Landscape Response

In respect of a Request for Further Information (RFI)

Ballyloo SID (ACP planning ref. 323860)

By Macro Works

Figure 1.11 Hedgerow Type 1: indicative boundary planting detail showing the approach to inter-planting and under-planting of existing hedgerows (where consolidation is needed).

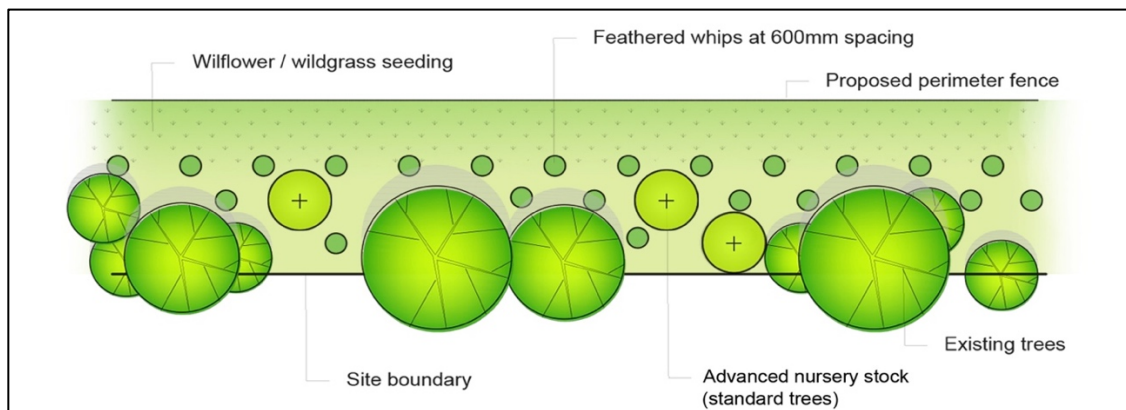
“While it is stated in several instances throughout the application documentation that the proposed development shall be carried out at the same time as the permitted Ballyloo Solar Farm (Carlow County Council Reference 24/60043 / An Coimisiún Pleanála Reference ABP-322347-25), every grant of planning permission is a stand-alone permission. In that context, the application includes three separate landscape mitigation plans for the three proposed substation options. With the exception of a proposed 30m section of hedging to the south of the proposed access from the L3050, the three plans do not show any landscaping proposals around the substations.

Therefore, it is considered reasonable that a revised set of layout plans is provided, identifying the entirety of the landscaping proposals that would be put in place to allow the impact assessment conclusion that have been set out in the LVIA to be reached, as they are represented in the LVIA photomontages. The response should also set out a commitment that the necessary landscaping works would be carried out as part of the substation development, in the event that the Ballyloo Solar Farm was not to proceed at the same time as the proposed substation."

In addition to this, and specifically in response to the further information request, it is proposed to establish approximately 755 sqm of new native thicket planting add the site entrance where some 30 m of existing hedgerow will be removed. Once established, the new native thicket planting will heavily diminish the potential for any clear visibility of the proposed development from the adjacent local road and from its local surroundings.

With regard to hedgerow removal, in addition to the approximately 30 linear metres of existing hedgerow vegetation to be permanently removed to facilitate the site access, as previously consented under Carlow County Council Reference 24/60043 / An Coimisiún Pleanála Reference ABP-322347-25, approximately 2 linear metres of additional hedgerow removal will be required to facilitate the installation of the proposed underground cables to the west of the site entrance. This represents a very limited and localised intervention in the existing hedgerow network. Furthermore, this section will be fully reinstated following completion of the construction works in accordance with the Hedgerow Type 2 shown on the updated landscape plans.

- **Hedgerow Type 1:** approximately 243 linear metres (as permitted under Ref. 24/60043 / ABP-322347-25);
- **Hedgerow Type 2:** approximately 283 linear metres (as permitted under Ref. 24/60043 / ABP-322347-25);
- **Native thicket planting:** approximately 755 m² (additional mitigation proposed as part of this Further Information response);
- **Permanent hedgerow removal:** approximately 30 linear metres to facilitate the site entrance (as permitted under Ref. 24/60043 / ABP-322347-25); and
- **Temporary hedgerow removal and reinstatement:** approximately 2 linear metres to facilitate the proposed underground cables, to be reinstated as per Hedgerow Type 2. 1 no. linear metre of removal / reinstatement related to Option A for the final underground grid connection cabling to the Kellis substation.
